June 5, 2013

*Re: Facility located at 15 Exchange Street  
Portland, ME  
Architectural Code Review: International Building Code (IBC-2009 edition), the  
International Existing Building Code (IEBC-2009 edition), MUBEC, NFPA 101-2009,  
NFPA 1-2006.*

FIRST FLOOR

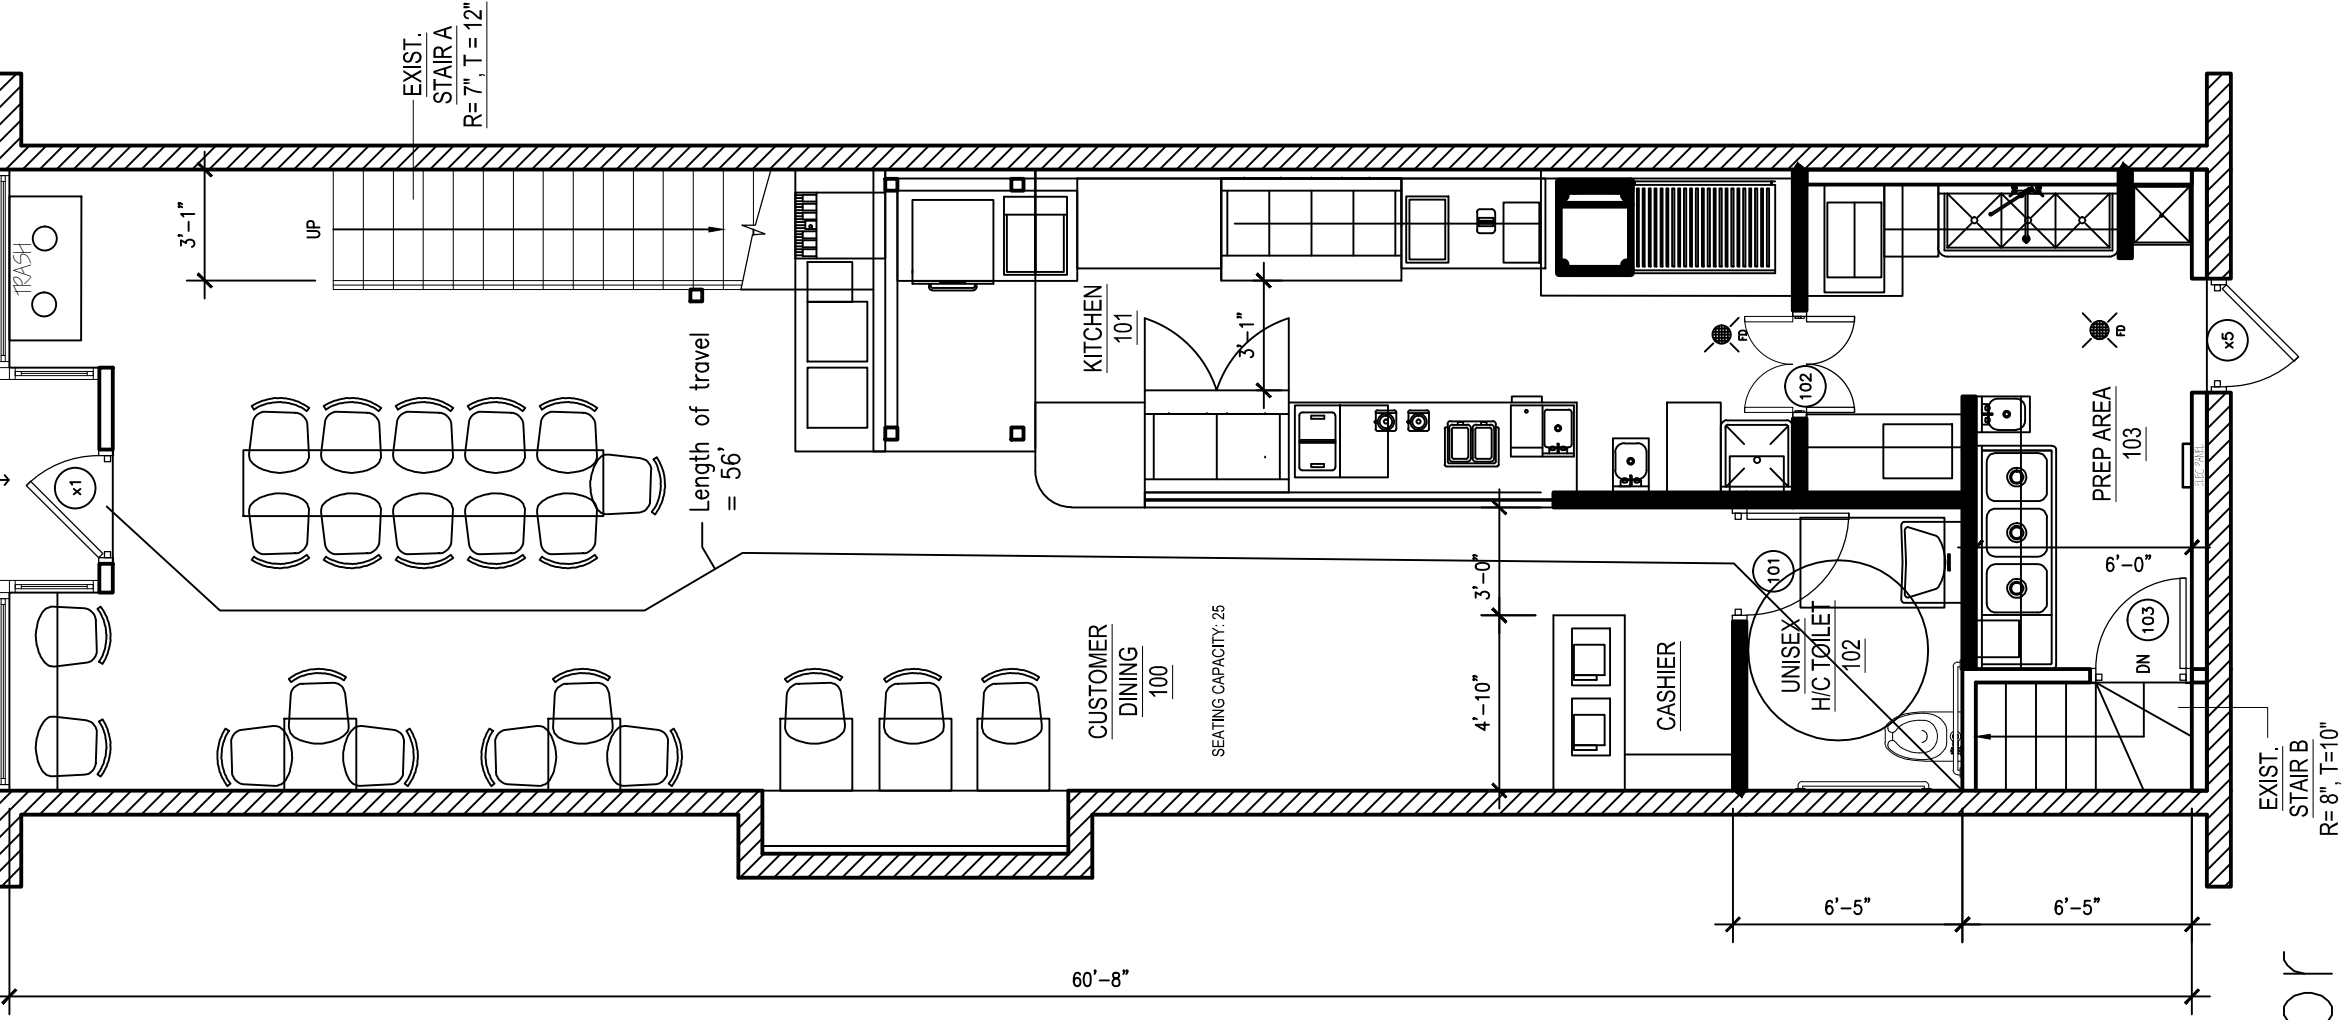
- 703.2.3 No remedial work required for supplemental stairway enclosures. **Please note that a 1 hour rated enclosure shall be added to the first floor of existing Stair B.**

First floor door width offered:  $x1 = 34''$  clear width =  $34'' / .2''$  per person = 170 occupants > actual 28 occupants, OK.

First floor door x5 offers 32" clear width =  $32"/.2$  per person = 160 occupants > actual of 3 staff, OK.

- 1016.1 Travel distance: Per Table 1016.1 for S-1 use, sprinklered = 250' maximum > 74'+/- provided (from room 001 to door x5 exit). For B use on first floor: 300' maximum > 56' provided (from room 102 to door x1 exit). For B use on second floor: 300' maximum > 62' from Dining to exit door x13 and 71' from Storage to exit door x13, OK.

First Floor B use = 49 occupants max. and 100' max. travel (due to sprinklers). Provided = less than 49 occupants and travel distance = 56', OK for story with one exit.

As cited in 704.1.1 above the corridors may be non-rated. Note: However, new door 103 shall be rated.

## SECOND FLOOR

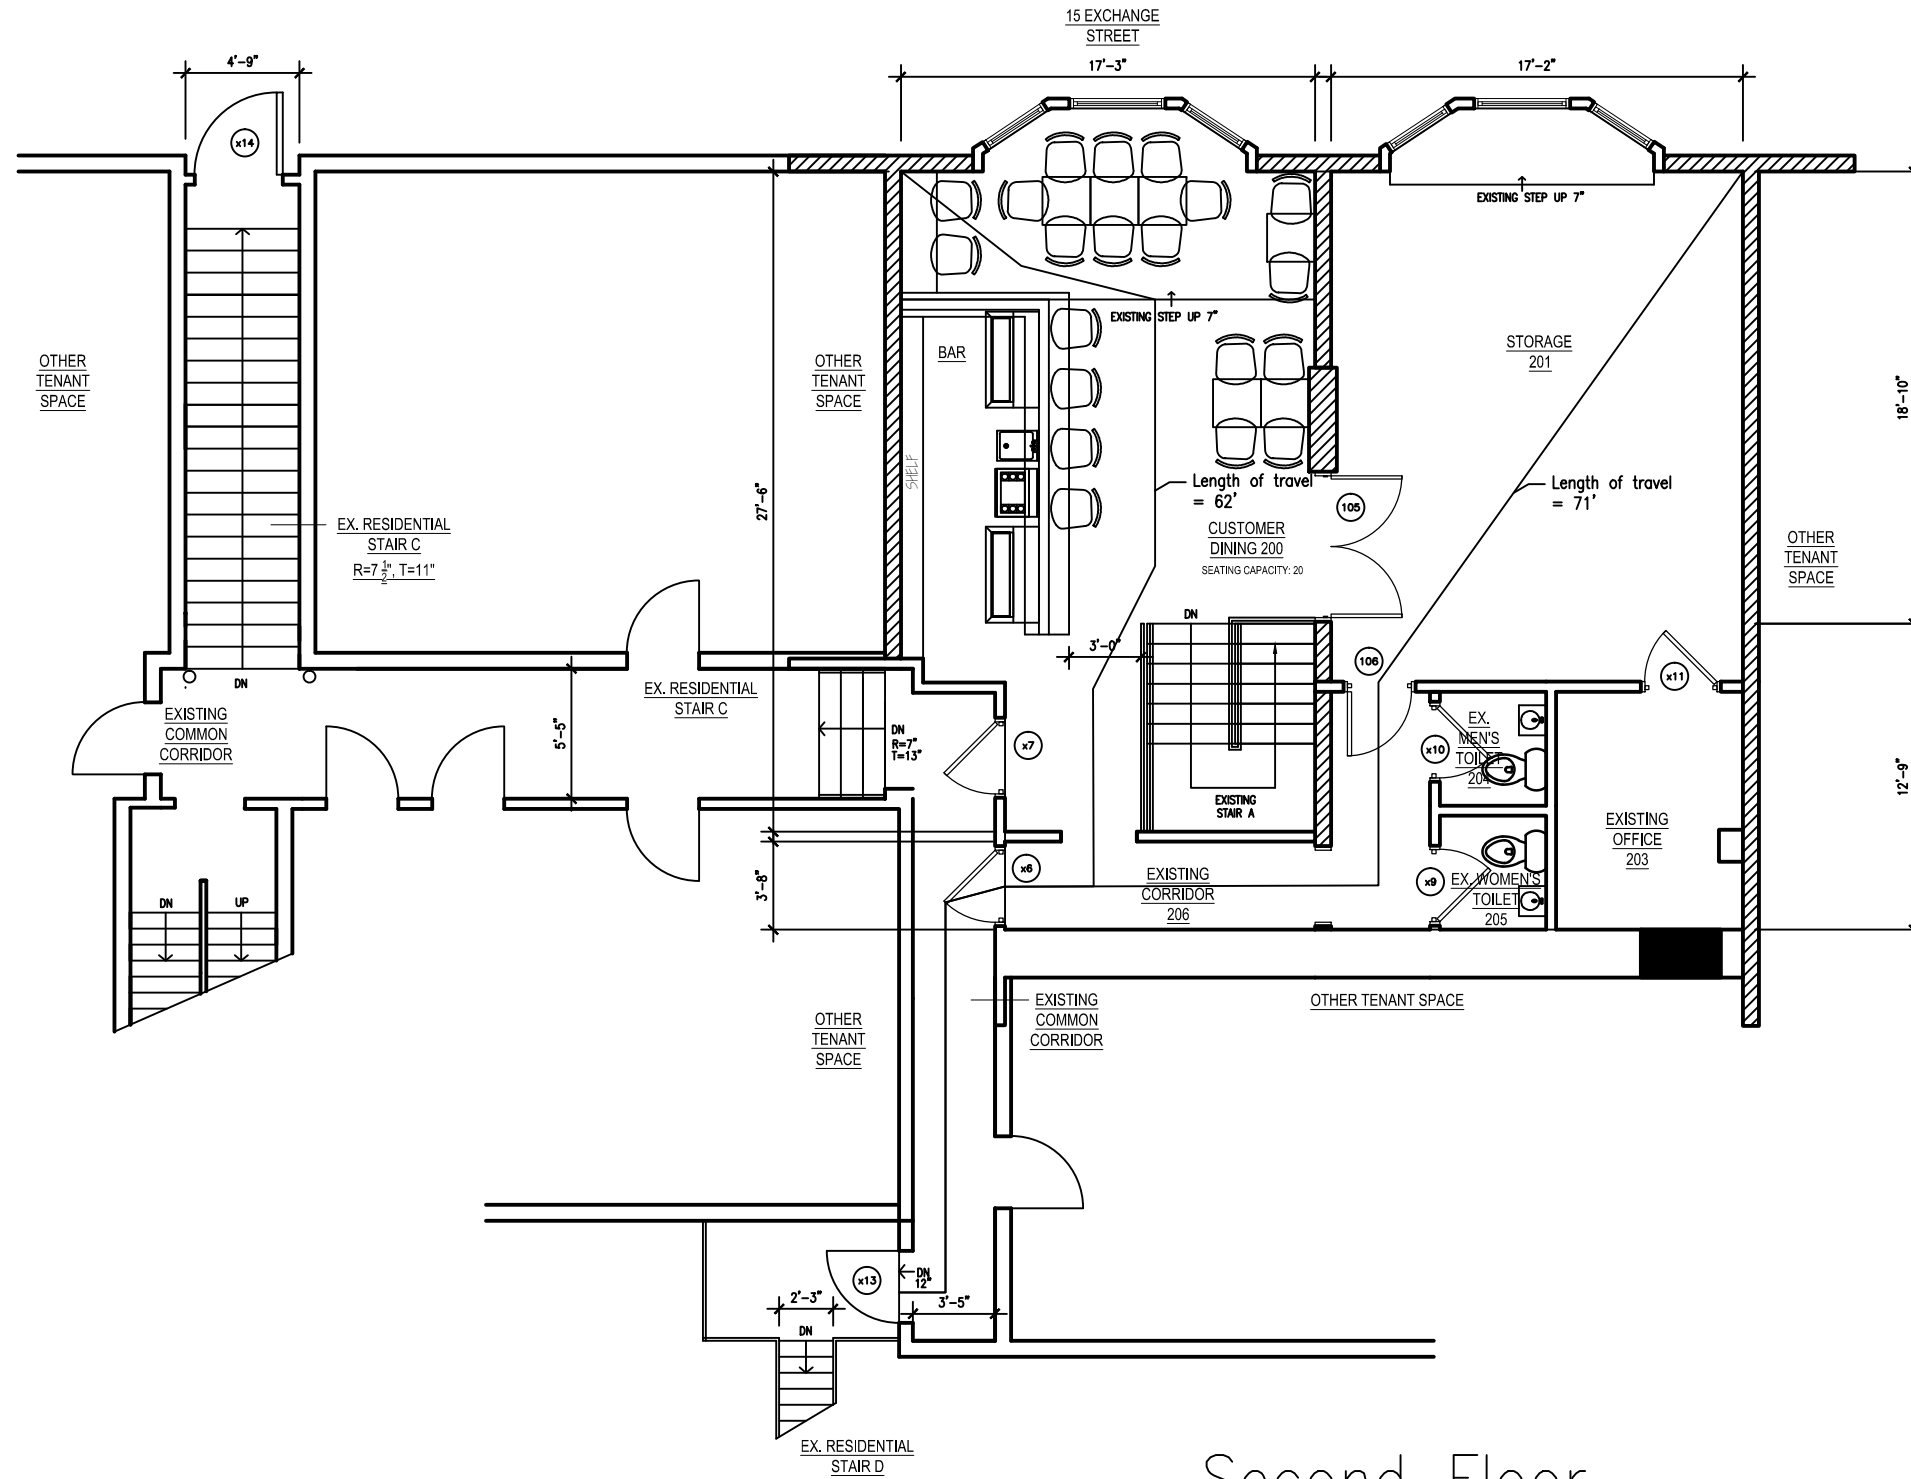
Second floor door x7 offers 32" clear width =  $32"/.2$  per person = 160 occupants > actual of 24 persons actual, OK.

- 1005.2 Door encroachment: Doors opening into the path of egress travel shall not reduce the required width to less than  $\frac{1}{2}$  during the course of the swing. When fully open the door shall not project more than 7" into the required width. Second floor residential corridor width adjacent to door x7 is assumed required 36" per 1018.2 (2). Actual corridor minimum width is 3'-5" leading to fire escape. Door x7 does not encroach more than the required  $\frac{1}{2}$  of the 38" path.

Second floor S use = 29 occupants max. and 75' max. travel distance. Provided = less than 29 occupants and travel distance = 71', OK for story with one exit.

Second Floor B use = 29 occupants max. and 75' max. travel. Provided = less than 49 occupants and travel distance = 62', OK for story with one exit.

Note: Doors x7 and x6 are rated for 1 ½ hours. Exiting through door x7 and to the street via Ex. Stair C to door x14 appears to be a more direct route. The max. length of travel for the B use to door x14 = 91' and the S use to door x14 = 110'. Although over the 75' limit (but less than the 300' cited in 1016.1) it would appear that the existing party wall and the 1 ½ hour rated door x7 would offer the mitigating factor of a horizontal exit. **Building inspector review is requested on this item.**
